R/79/18/NMA

Application for a non-material amendment following a grant of planning permission.

SINGLE STOREY SIDE EXTENSION.

THE REMOVAL OF 2 SIDE VELUX WINDOWS + INSTALL
1 x 1m x 2m FLAT ROOF LIGHT WELL.

BAR SCALE (METRES)
SCALE 1:100@A3 DRAWN 1A APR 10
DRG No. 16212 P 01

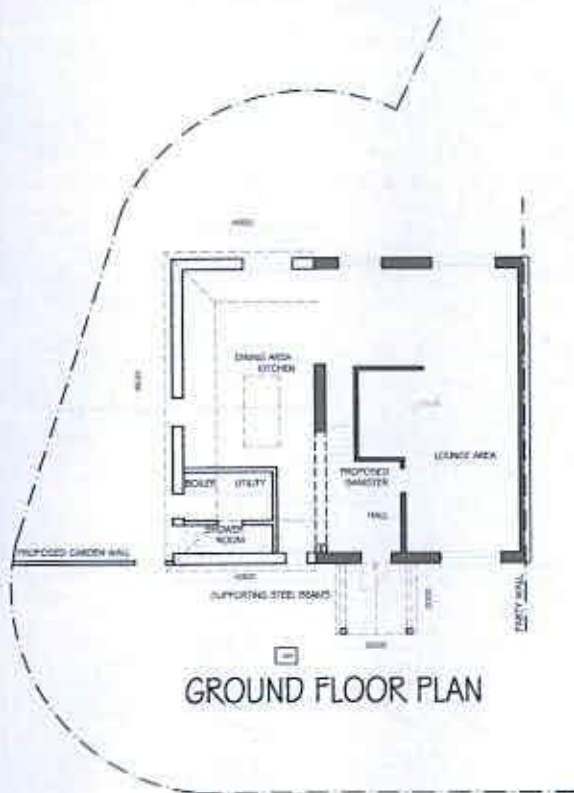
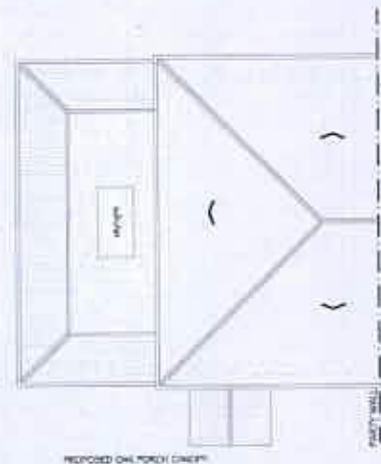
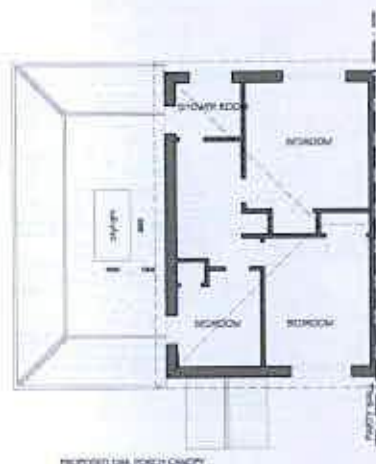
DUE TO THE ARCHITECT POSITIONING AN EXISTING WINDOW IN THE WRONG POSITION
ON THE ORIGINAL PLANS, ROOF LINE HAS HAD TO BE LOWERED FOR
THE STEEL BEAMS TO FIT. THE 2 SIDE VELUX'S WILL BE TOO
SMALL AND POINTLESS.
